Our ref: WA/2023/130772/03-L01

Your ref: 23/02098/OUT

Date: 28 August 2024

Begbroke Science Park And Surrounding Land

Figure 6.1: Location of Swale in the North-west of the site

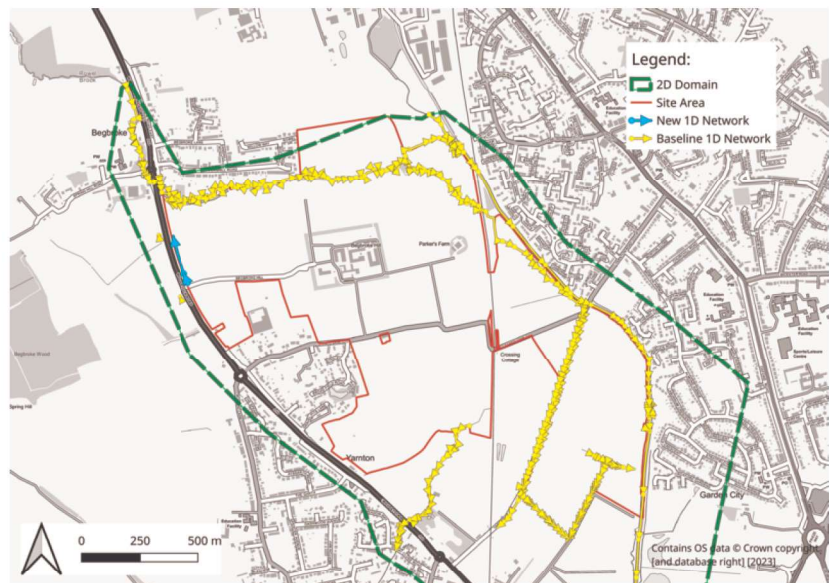
The applicant proposes to obstruct a flow route in the northwest of the site, which is likely to increase flood risk elsewhere as the displaced flood water would find a new flow route. We would expect level for level compensation to be proposed for the loss of floodplain storage (the area that will be prevented from flooding). Instead, a swale is proposed, and it is unclear how the swale would function. If the water is channelled into a narrow ditch, this could increase the efficiency of flood flows, moving more water downstream at a greater rate which could increase flood risk elsewhere. It may be the swale would be designed to mimic the existing flood flow, however this would need to be demonstrated through modelling and plans clearly identifying how the swale would function. Further information is therefore required in order to show there would be no detriment, including considering timing of any flooding offsite.

Further, whilst attenuating the displaced flood water in a swale may hold water upstream in an initial rainfall event, if the attenuation area/swale cannot freely drain into the river then there may be less storage available for any future floodwater should there be further rainfall event. This could also increase flood risk elsewhere. We would not have these concerns if level for level compensation was proposed, as flood water would be able to freely enter and exit the floodplain storage area during and after an event. More information is therefore required on the proposed swale unless, ideally, it can be replaced with level for level compensation.

In addition, the applicant should also provide more information on the proposed swale including:

- Confirmation that the swale is only to mitigate for the 1% AEP plus higher CC allowance flood events and above, and that floodplain storage for lower order events will be maintained such that the floodplain will function as it does in the pre-development scenario.

- An explanation and plans that demonstrate how the swale would function in practise, clearly setting out the design principles. This should include whether the swale would be hydraulically connected to the floodplain or watercourses. Would the scheme change the timing of a flood event? If so, what would the impacts be? Would it create a more efficient flow path, increasing flows downstream? How would the works affect the A44? Would there be any benefits of the scheme?

- How the swale will drain after heavy rainfall and how would this affect fluvial flood flows into and out of the swale? This is to identify whether storage would be available should there be a second flood event shortly after an initial event

- Confirmation that these works are possible within the RLB, and if not, how they would be achieved

In relation to 6.4 of the Design Note, it is not clear how the proposed swale is more sustainable than the existing situation, as it appears that a more engineered approach is proposed.

Figure 6.5: Difference in flood level between the baseline model and the North-west mitigation scenario in the 1% AEP event plus 41% allowance for climate change, 11 hour storm duration

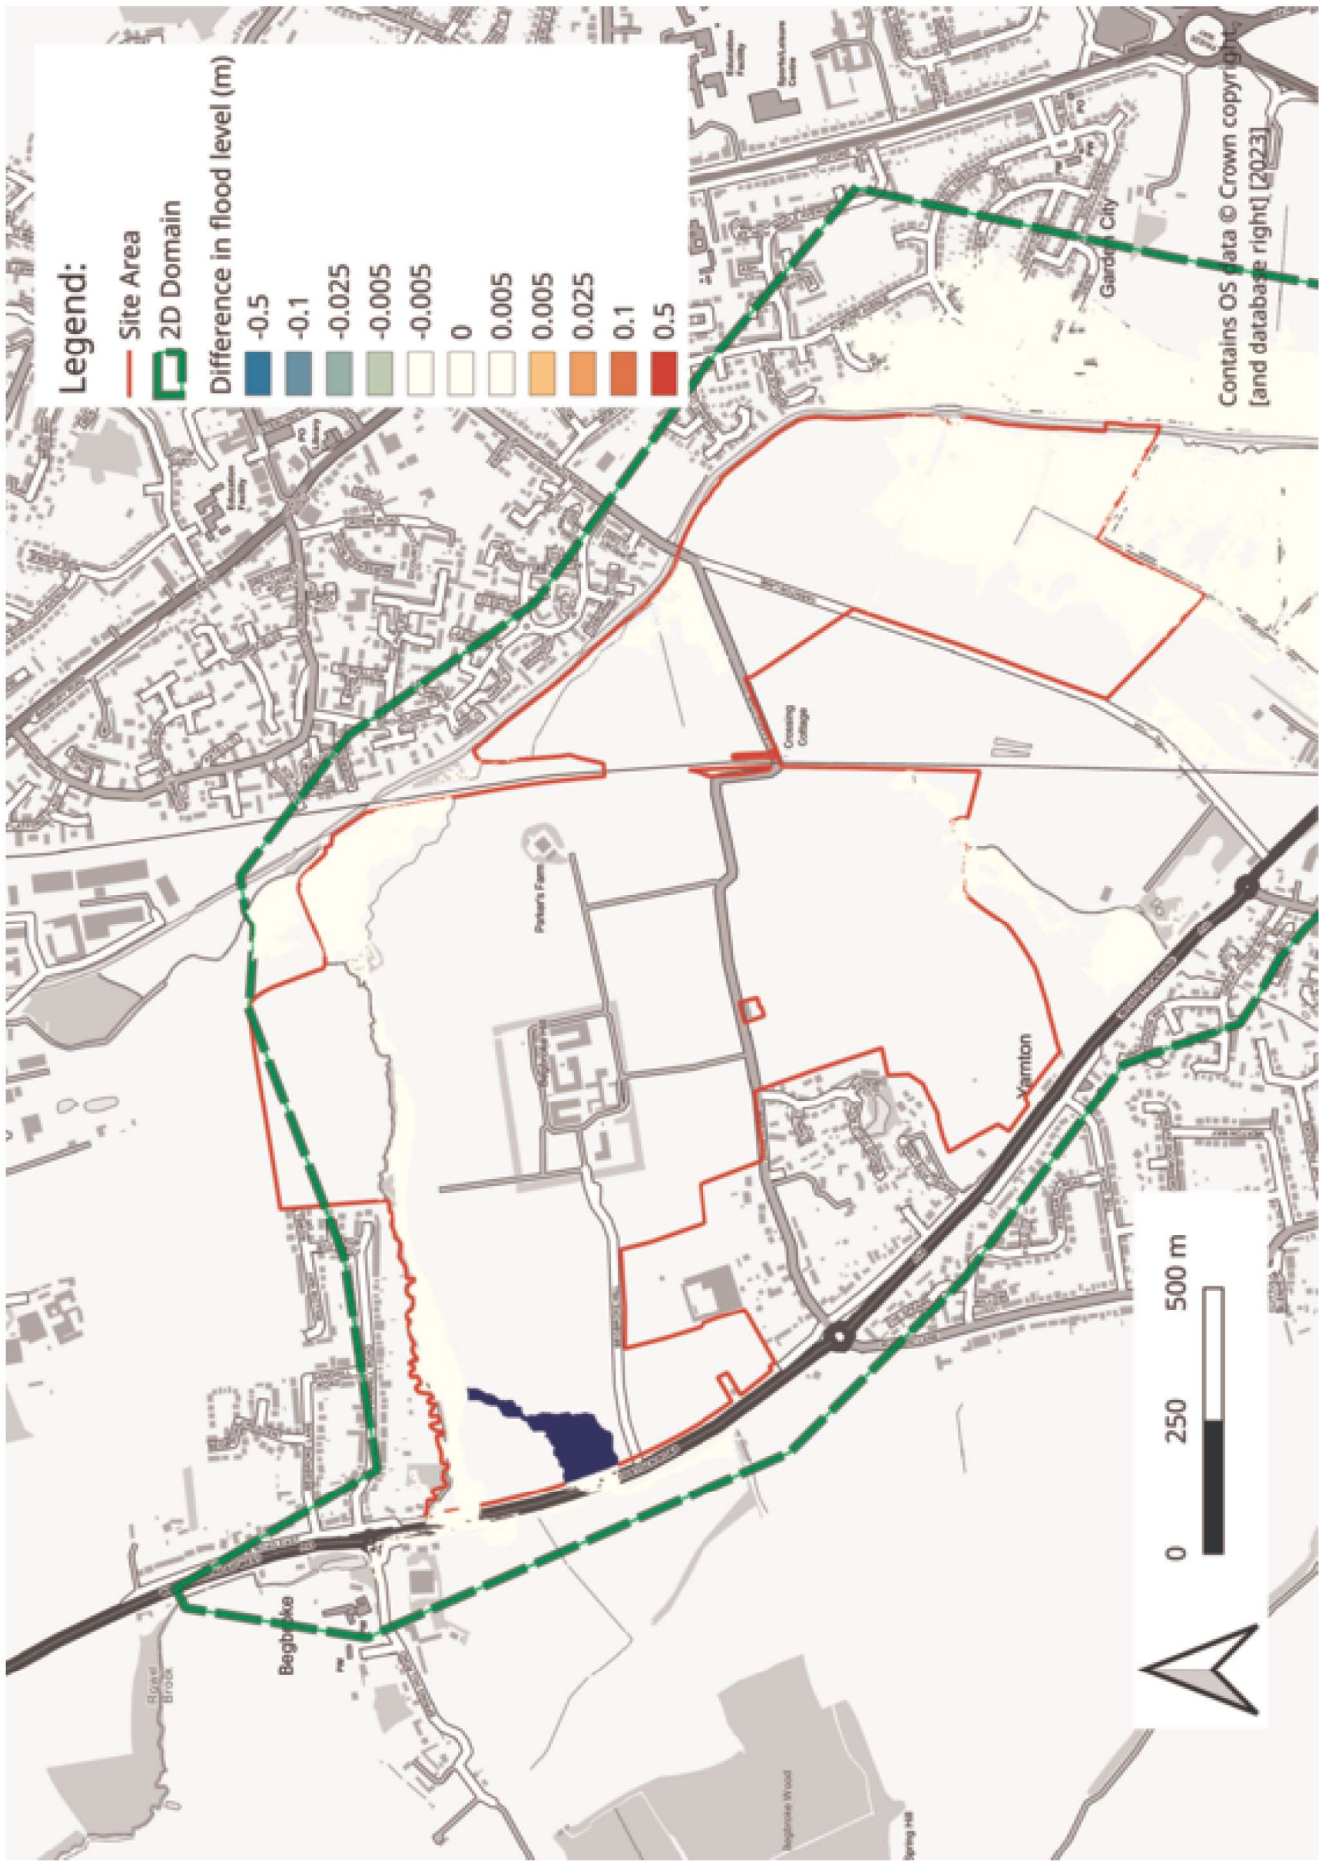
We have provided the following comments for if a swale is the only mitigation feasible option and the applicant can demonstrate there would be no detriment. The submitted Design Note highlights 'difference plots presenting difference in modelled flood depths and extents shown in Figure 6.5 and 6.6 of the updated Hydraulic Modelling Report'. Unfortunately, the resolution of these figures in the Model Report are too low for us to review (the proposed swale is not distinguishable from the RLB). Please can you request high resolution versions of these figures are provided. This mapping should clearly identify where the swale is proposed and what impact the works would have on flood risk on and offsite.

- In relation to the 6.5 of the Design Note, the flow route of the ordinary course on the other side of the A44 is not clear. Our mapping identifies a culvert under the A44 and across the site, broadly following the flood extent shown during the 0.1% AEP event. There is limited information in section 4 of the Model Report: does this watercourse go into a culvert, and if so, where does this culvert discharge? If this culvert is present, what capacity does it have? The flow route across the road may be due to a low point in the road at the same height as the watercourse being bank full, or the culvert surcharging and levels increasing in the upstream reach before overtopping. Is there open channel on either side of the A44 connecting the ordinary watercourse to the Rowel Brook in the north? Note any key details set out in the Model Report should also be set out in the FRA to explain the principle of what is proposed.
